Re: Los Candelarias Subdivision, SIA/Financial Guarantee Release

Engineer's Stamp dated 4-29-03 (G14/D70)

Certification dated 2-09-04

Based upon the information provided in your submittal received 1-26-04, the above referenced certification cannot be approved until the following comments are addressed:

CITY OF ALBUQUERQUE
PUBLIC WORKS DEPARTMENT
ENGINEERING DEVELOPMENT GROUP
TITLE: LOS CANDELARIAS SUBDIVISION
GRADING PLAN
FEB 11 2004

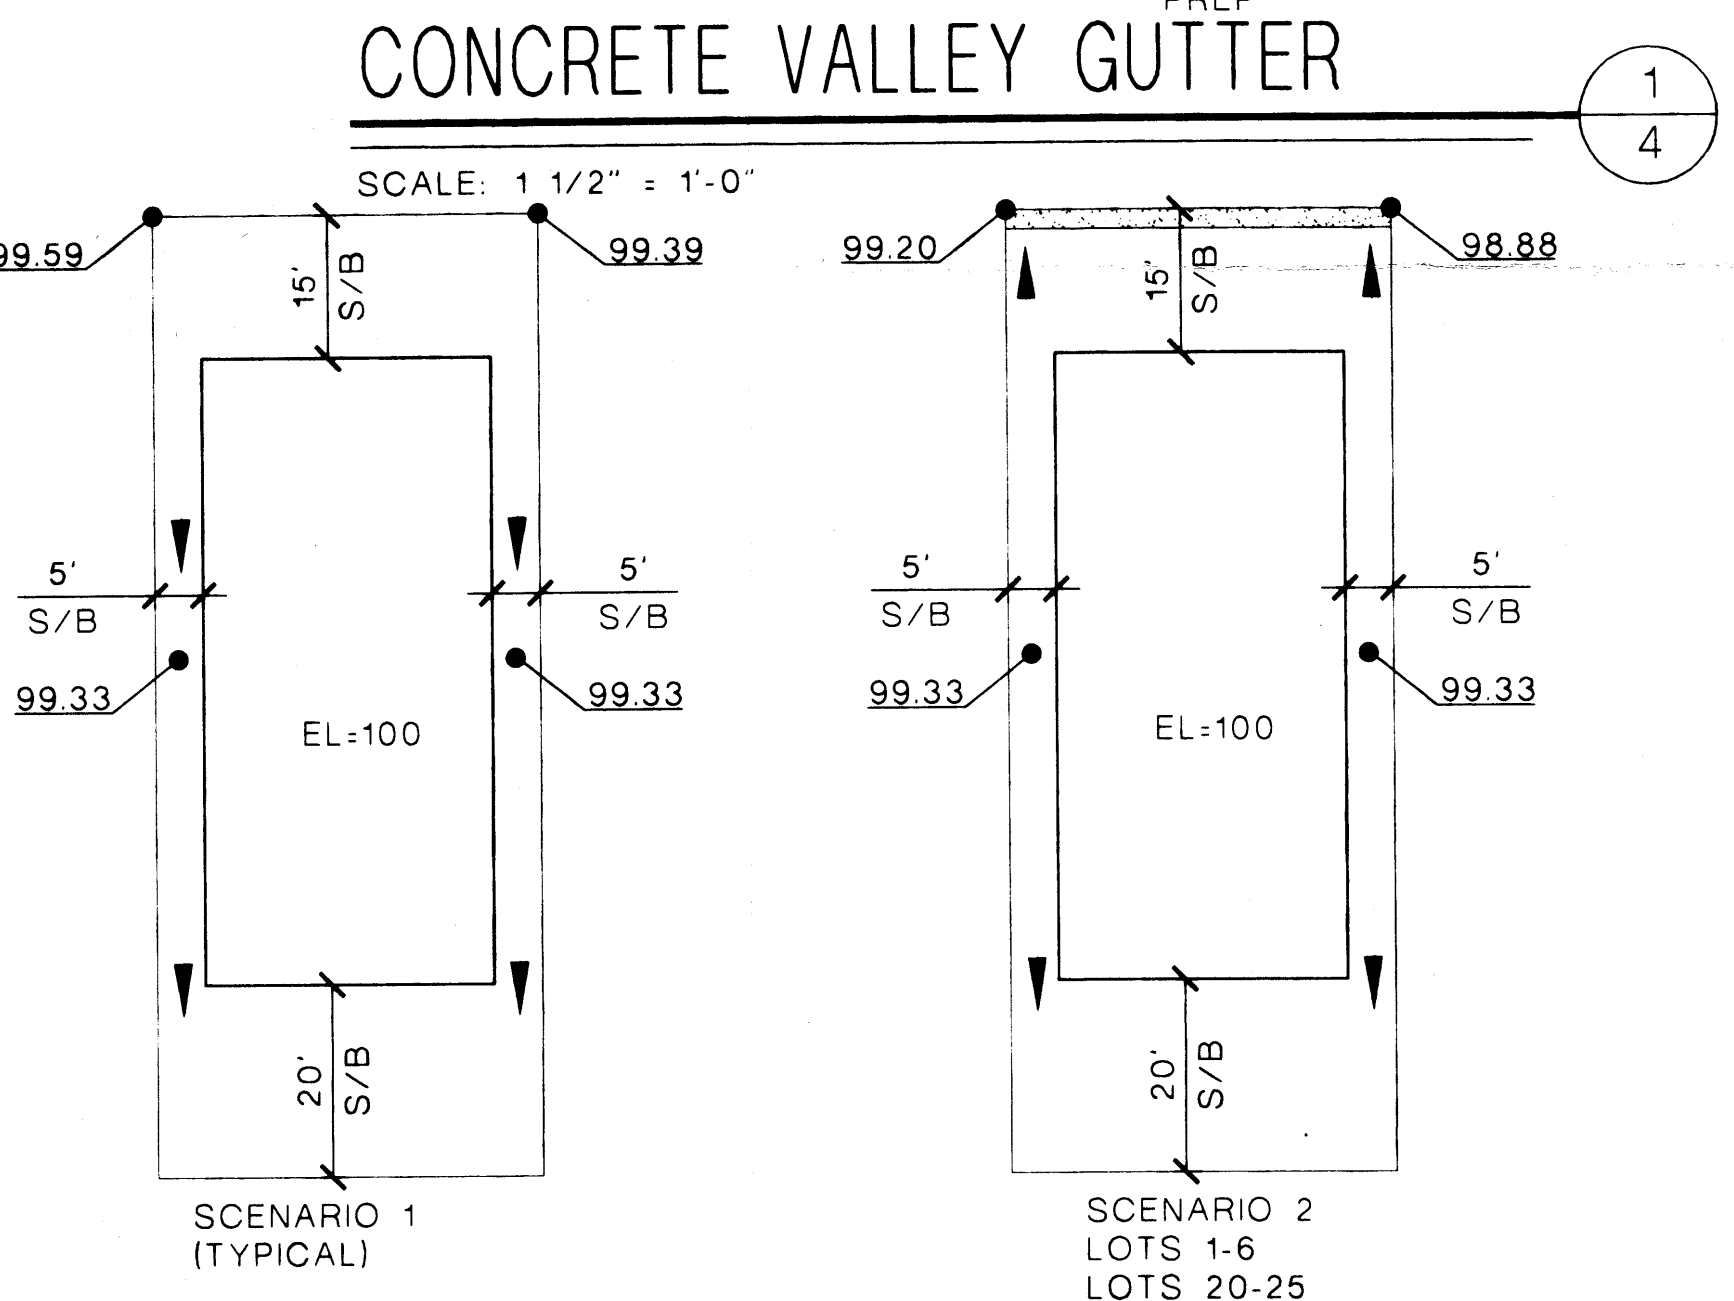
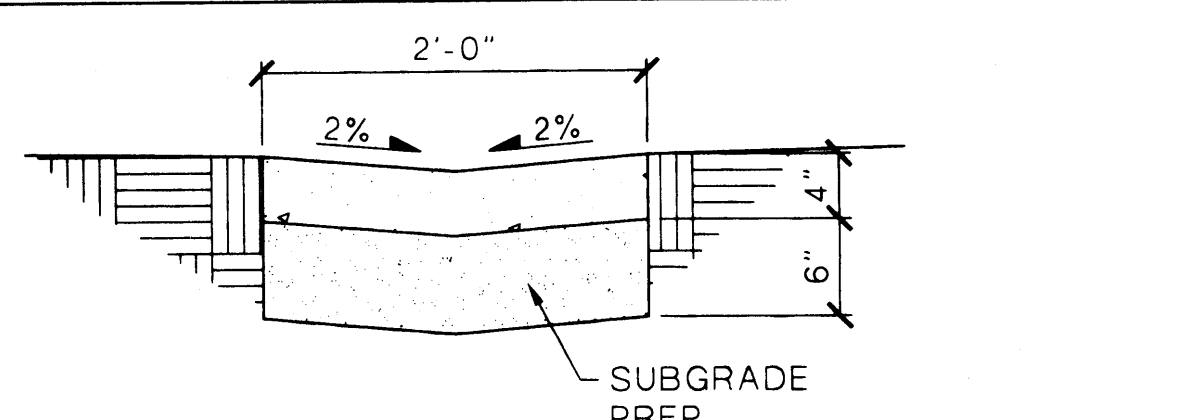
- 1. Please certify the hydrology-approved grading and drainage plan, dated February 19, 2003.
- 2. Please use the standard text for your certification. A sample of this is attached.
